FW: CM/16/26/HH 3 New Thatched Cottages

Please upload the attached documents to CM/16/26/HH
Additional document
'Flood risk assessment data'

The proposed development comprises a modest 37m² domestic garage within the curtilage of an existing dwelling. The garage will replace an existing shed and be constructed over an area currently occupied by impermeable hardstanding. As such, the proposal will not materially increase impermeable area or alter existing surface water runoff characteristics.

Drawing Title
SW Drainage Layout

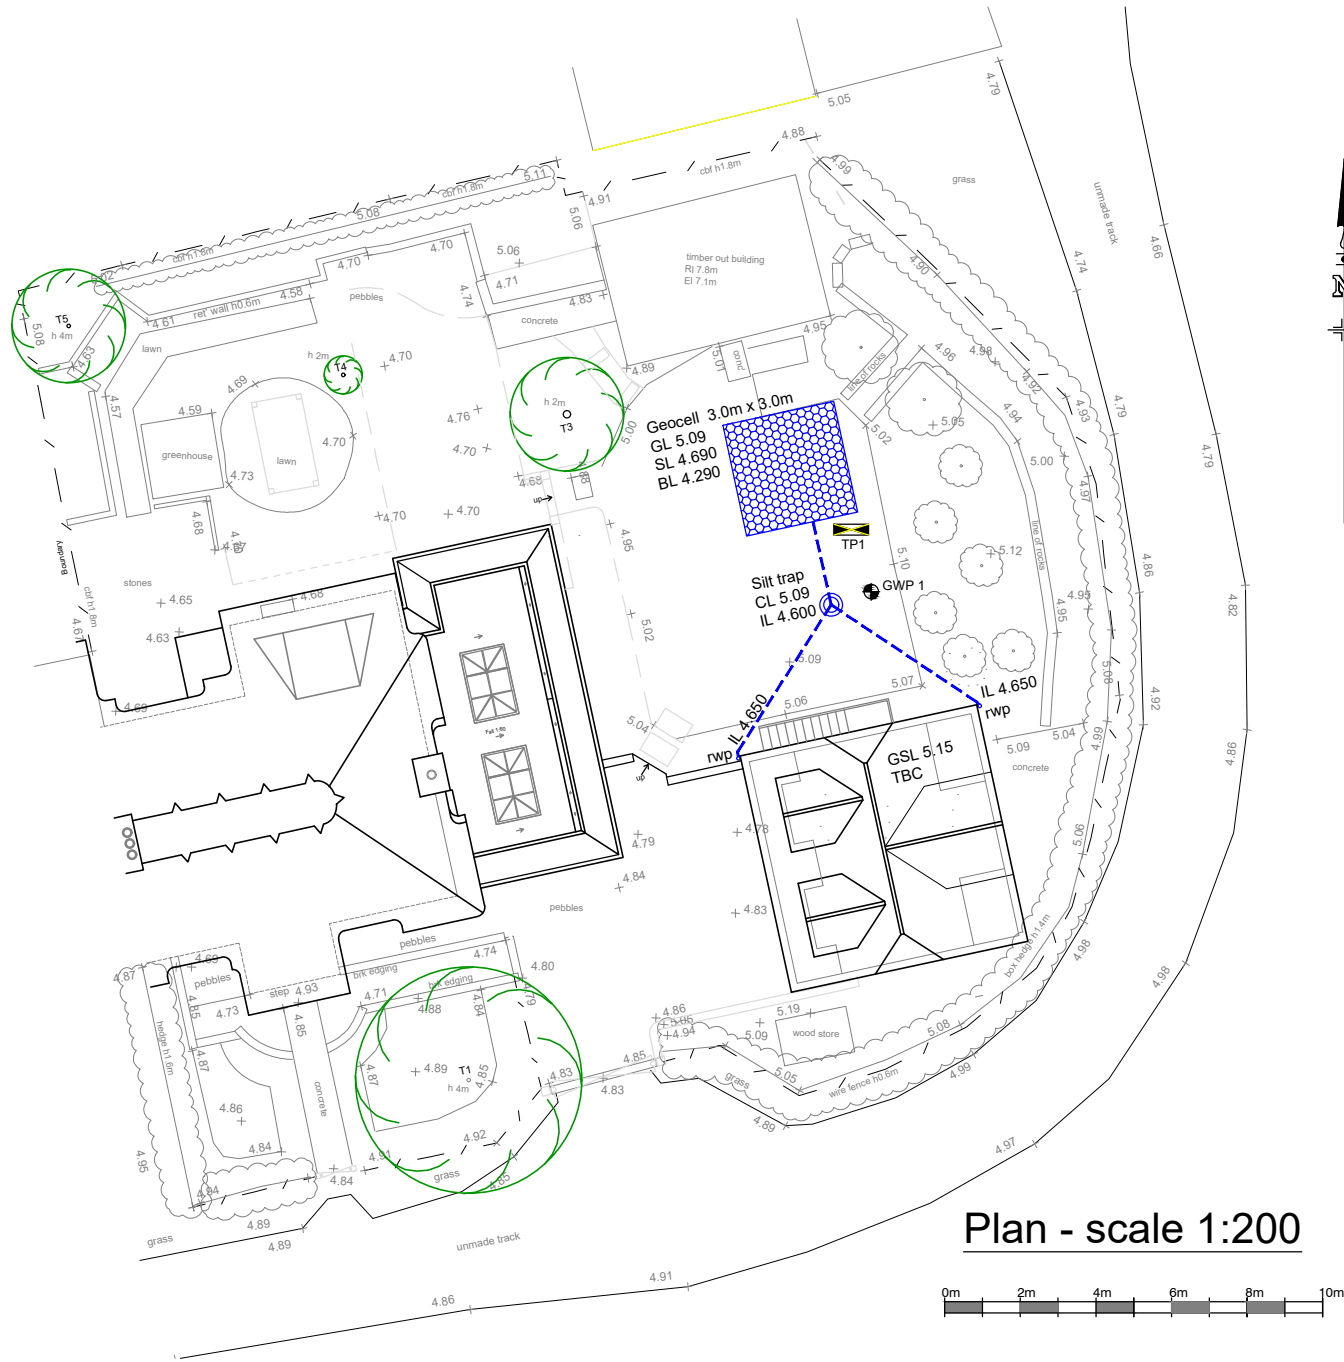
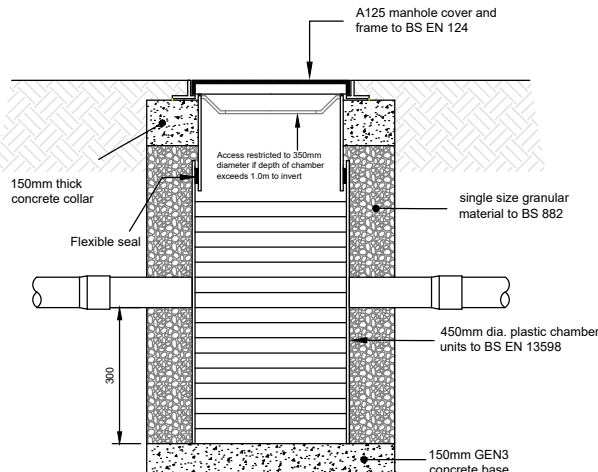
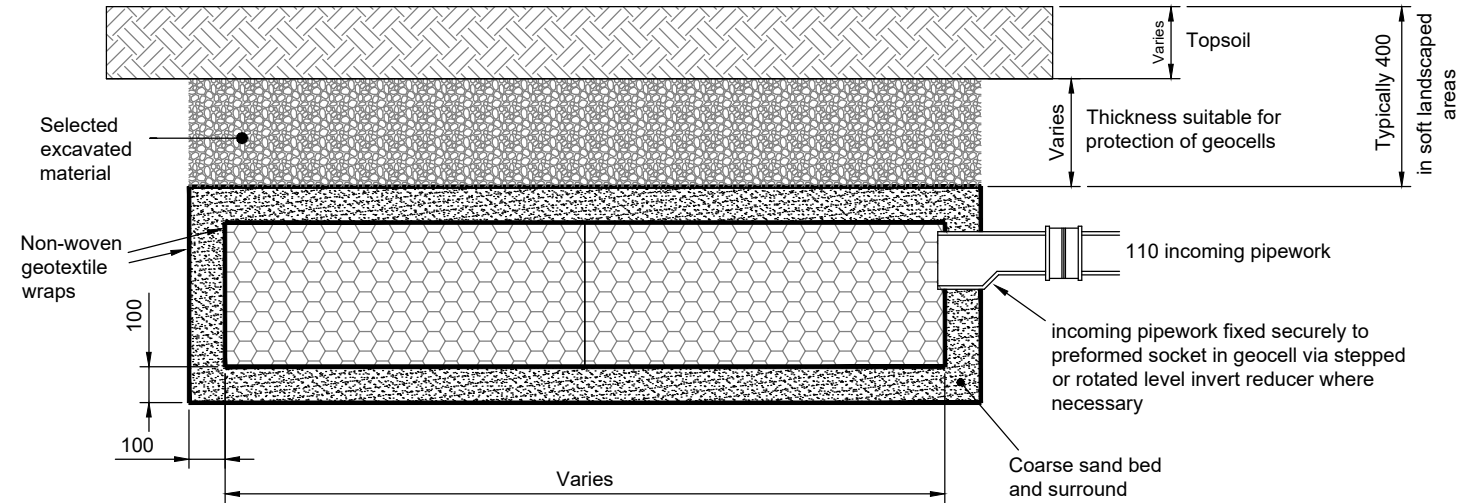
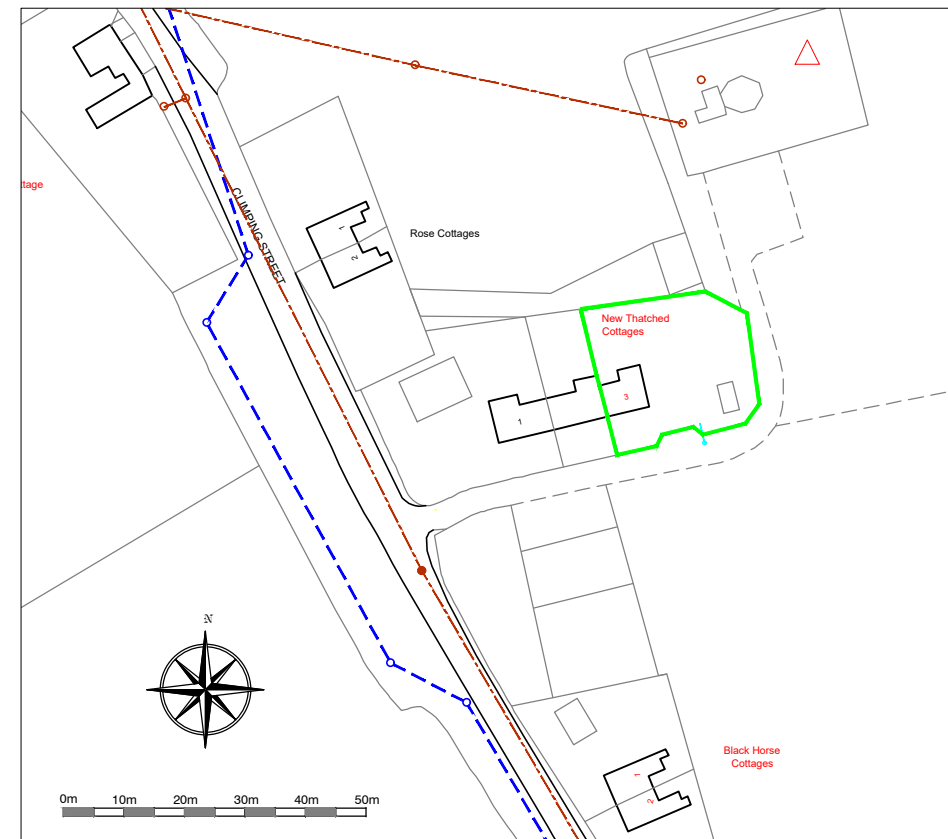
Nevertheless, the proposal incorporates a drainage strategy that directs roof runoff to an infiltration soakaway, representing a betterment over the existing situation, where runoff is unmanaged.

Paragraph 182 of the NPPF requires SuDS to be proportionate to the nature and scale of the proposal and states that multifunctional benefits should be provided "wherever possible", rather than as an absolute requirement

Given the small scale of the development, the absence of any material increase in runoff, and the proposed betterment through infiltration drainage, the LLFA's request for full multifunctional SuDS providing amenity, biodiversity and water quality benefits is considered disproportionate. Such features would necessarily be located within a private residential garden, where their long-term retention and management cannot reasonably be secured and where any wider public benefit would be negligible.

The proposed soakaway provides a practical, effective and policy-compliant drainage solution that is proportionate to the scale and impact of the development. It is therefore considered that the requirements of Paragraph 182 are satisfied, and that further multifunctional SuDS measures are neither necessary nor justified in this instance.

#3 New Thatched Cottages
Borehole #1 (South)

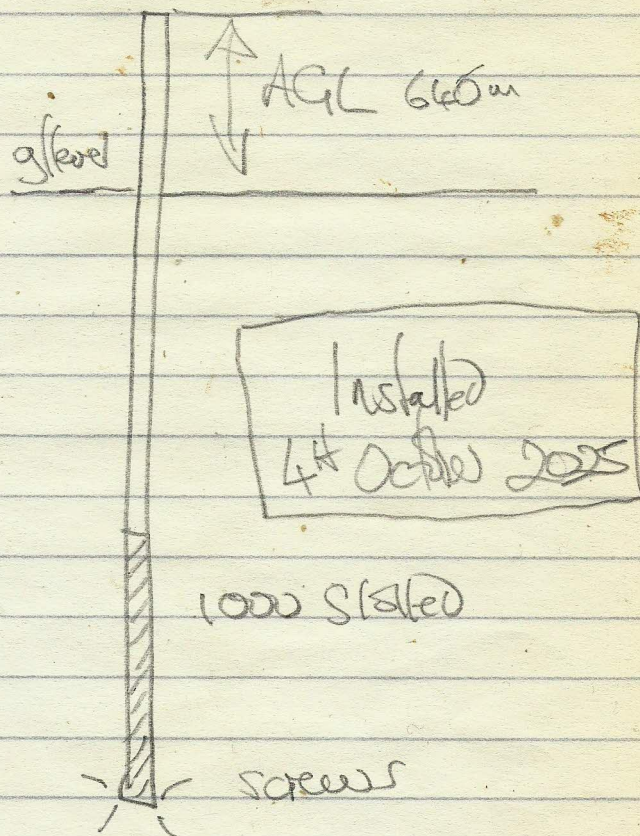
'Having read the drainage comments from the recent consultation, it appears that Arun DC would also expect details of the soil composition for the trial pit to be evidenced.'

There was no detailed soil log carried out as the Trial Pit was excavated a few days prior to Infiltration being carried out. However depths were measured, off the side-wall, immediately before testing with the following being recorded from ground level to the maximum depth of 880mm :

- a) 0mm - 450mm of top-soil including made-up towards the surface.*
- b) 450mm - 880mm of silty clay within the typical response zone.*

To correlate with this I am attaching, as a pdf, a scan of the Borehole Log for Groundwater Monitoring Point GWP#1, recorded on the days of installation. It should be noted that the location of the Trial Pit was approximately 1800mm from the monitoring point. Thus it is implied that the soil characteristics should be very similar.

As can be seen from this Borehole Log, the soils were :

- a) 0mm - 520mm of top-soil + made-up.*
- b) 520mm - 930mm of damp mouldable silty clay within the typical response zone.*

It should be noted that these soil descriptions are from visual characteristics only on Disturbed Samples removed during augering -- no Particle Size Analysis has been performed.

The borehole was initially augered on Tuesday 4th February 2025, to a depth of 2140mm Below Ground Level (BGL), with twice-weekly monitoring to establish (or not) the viability of Drainage-by-Infiltration as regards Freeboard.

On the 4th October 2025, this borehole was cleared of slumping soil at its base and an Open Head Piezometer (slotted monitoring pipe) was installed. Groundwater Monitoring to meet the requirements of Arun DC guidelines was carried out.
